October 5, 2018

Subject: Hunsinger Final Plat Amendment Review 1

File: VR-18-014

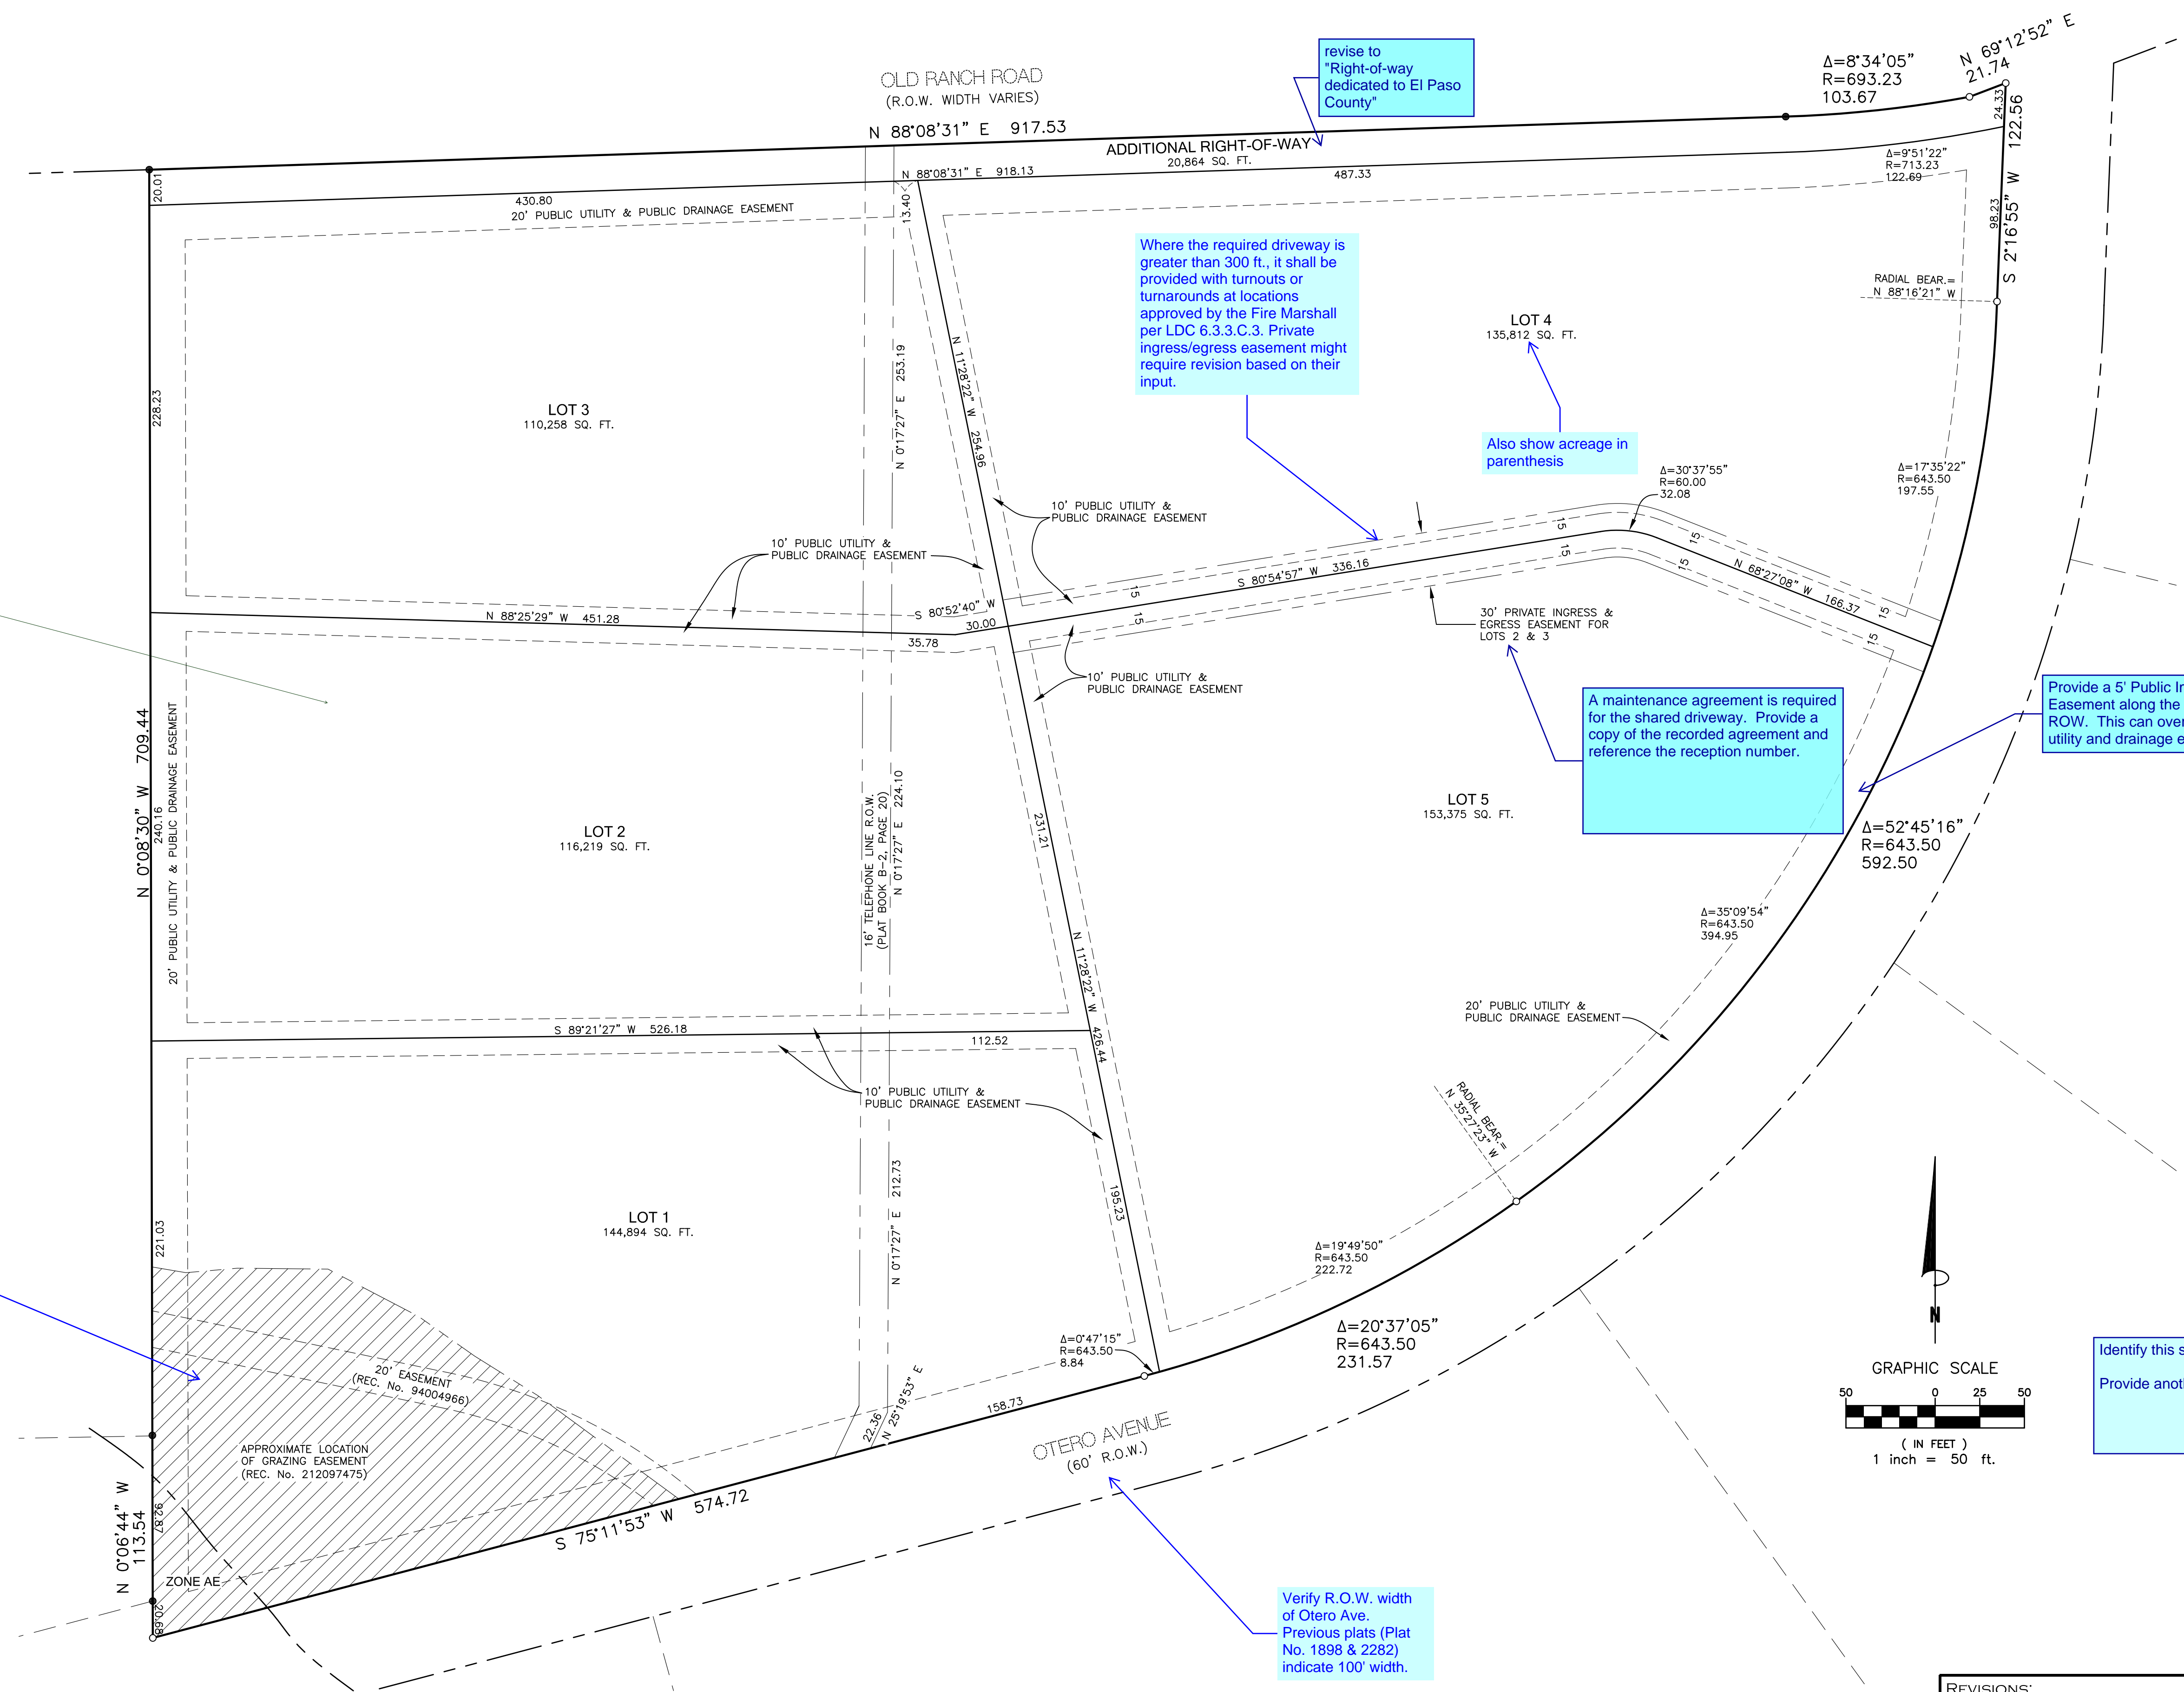
2. Label the existing utility easement for the existing gas main with width and Reception No.

MVEA notes the utility easements shown on the final plat of ten (10) foot side and rear lot line along with twenty (20) foot exterior utility easement. MVEA will request ten (10) foot utility easements outside and adjacent to the ingress & egress easement for the design of electrical facilities. MVEA also requests platting of existing MVEA facilities with easement on the plat. Additional easements may be required in order to serve this development.

No record of an easement along the existing gas main crossing the property has been found. The records reviewed show only a right of way along the gas main corridor. If CSU has records showing an easement in this location, please provide copies of them and the plat will be updated accordingly.
